From: Clerk Yapton Parish Council [REDACTED]
Sent: 23 April 2014 11:55
To: Simon Davis
Subject: Planning Application Y/22/14

PROPOSED ACCESS IMPROVEMENTS - scale 1:250

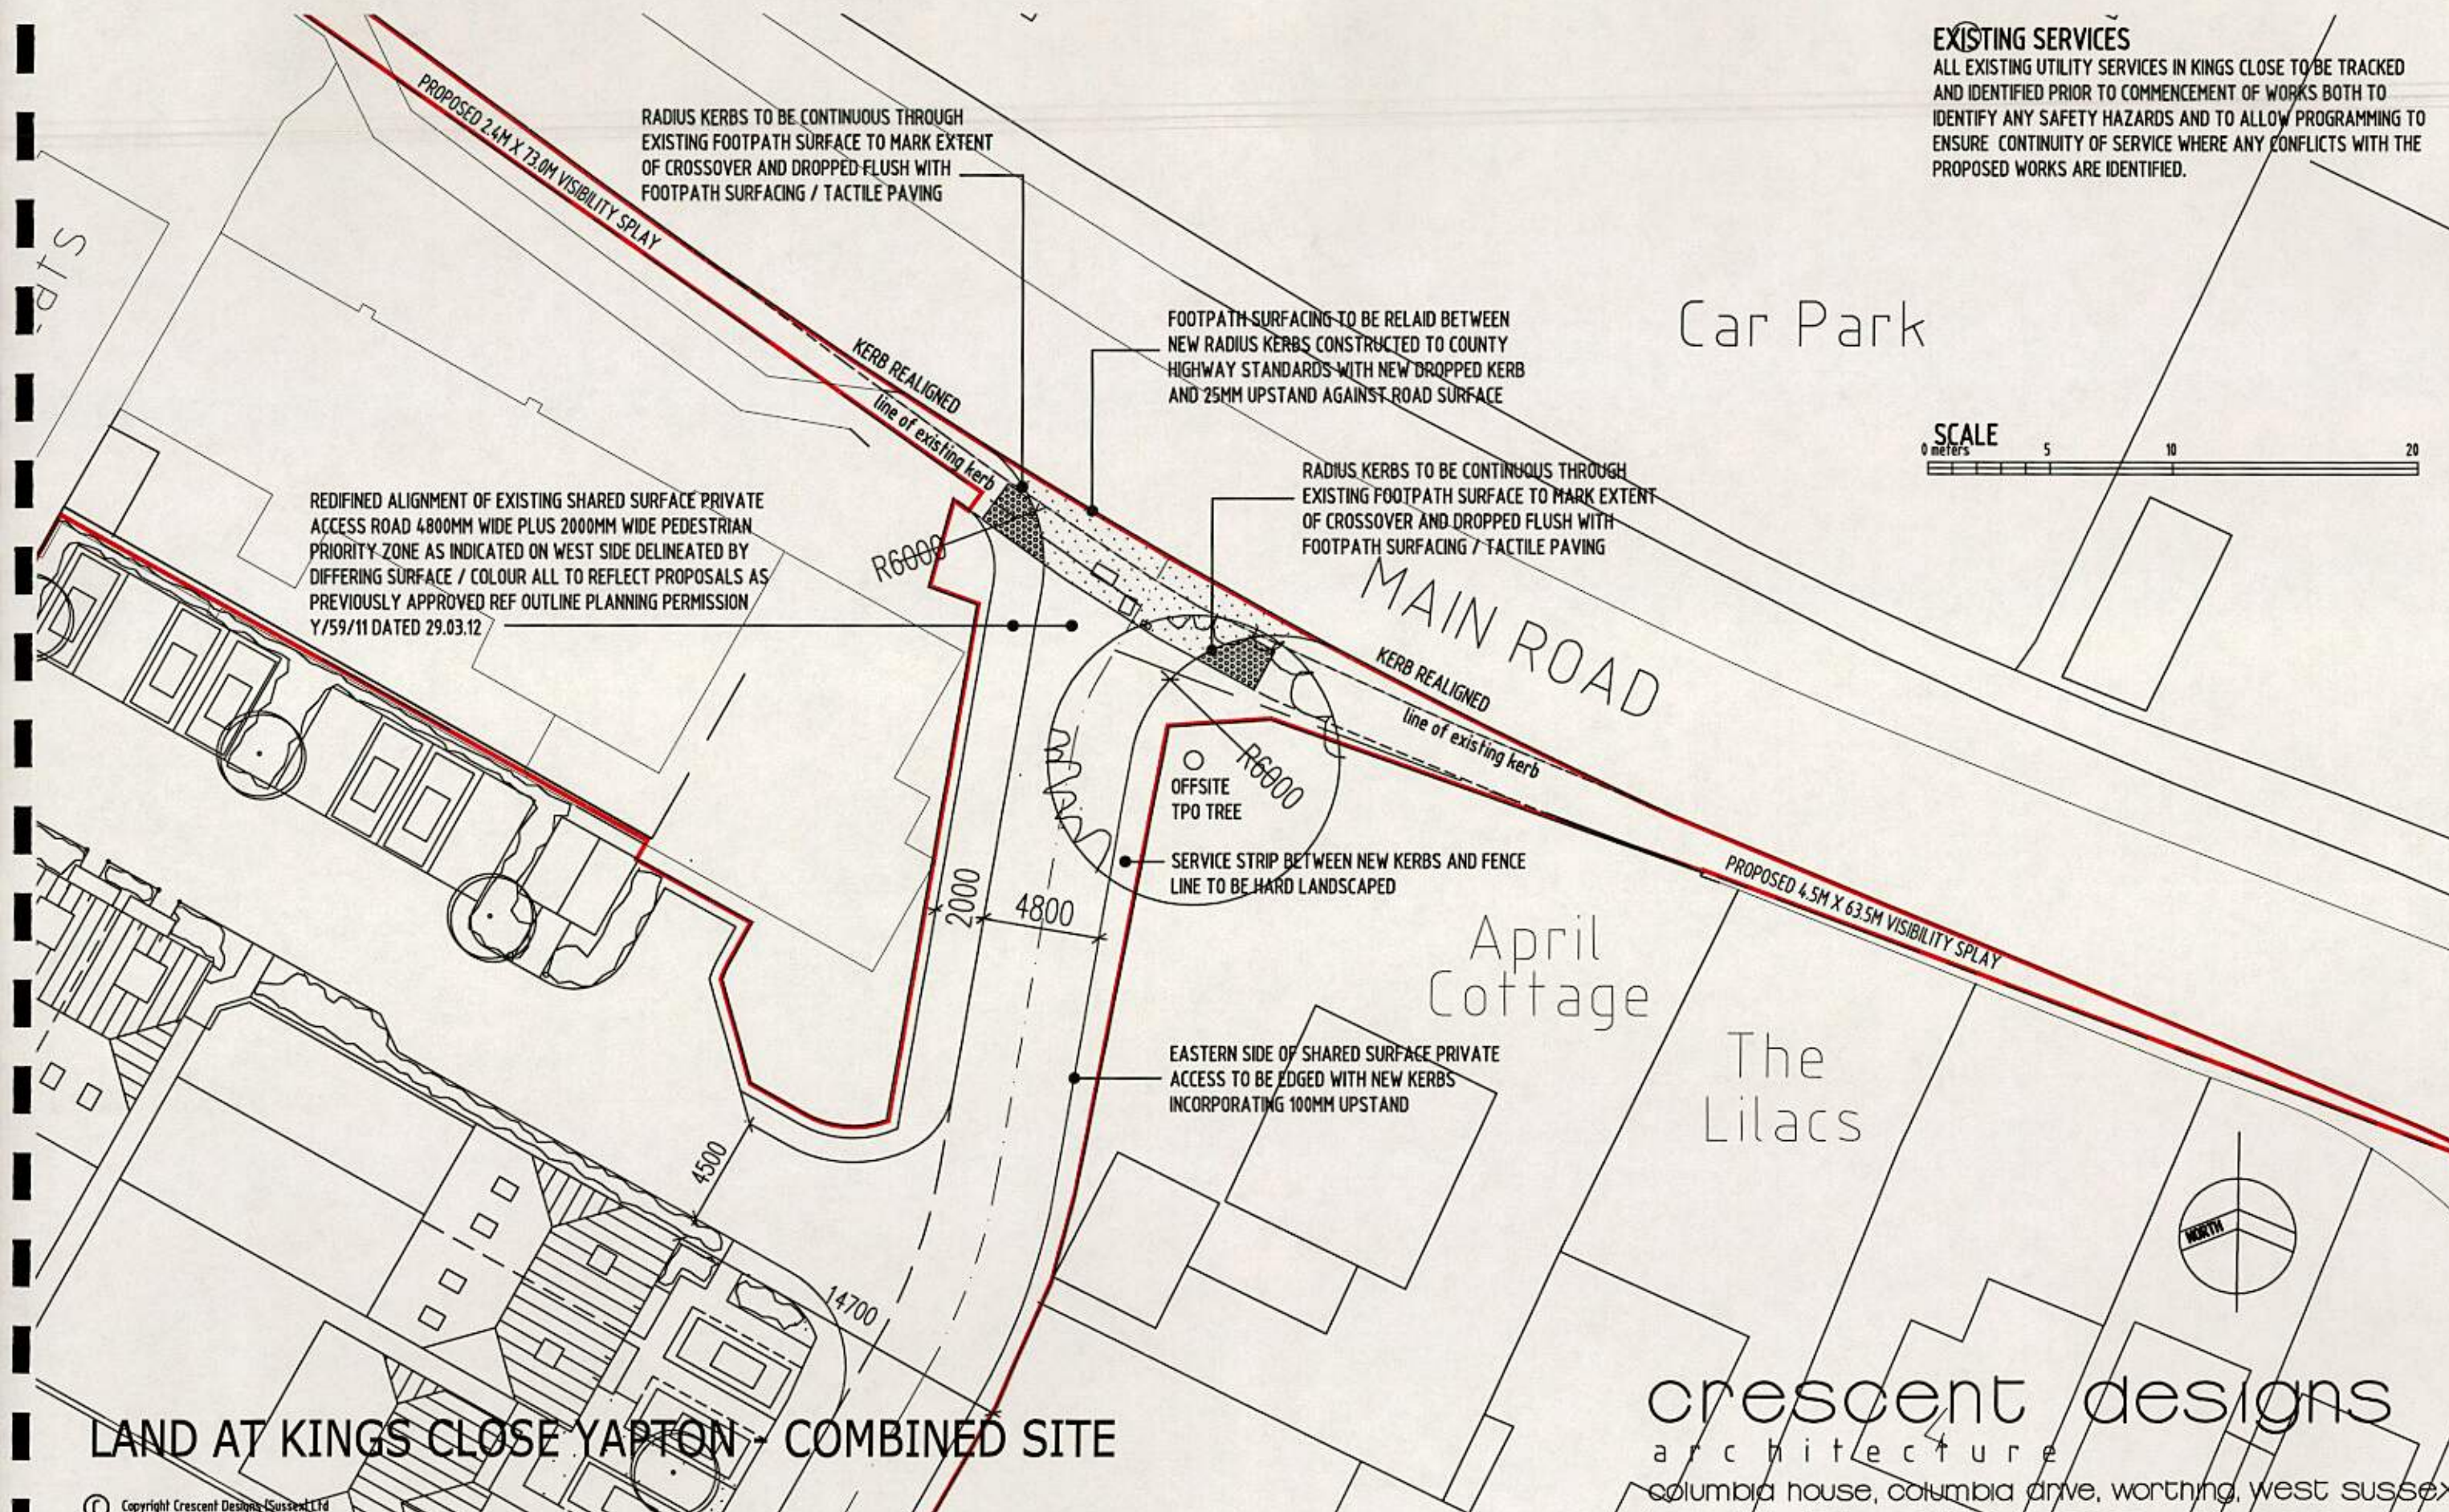
I have just forwarded to Arun under separate cover using the online system the Parish Council's comments with regard to this application. Attached is a photo which illustrates the problem which we have discussed with WSCC Highways (Ben Whiffin). Ben is proposing to reinstall bollards to discourage parking but in the past this has not proved much of a deterrent and it would probably be best if the pavement could be raised at this point as part of the highway works connected to the development.

In the interests of highway safety, the Parish Council would appreciate it if this could be considered please.
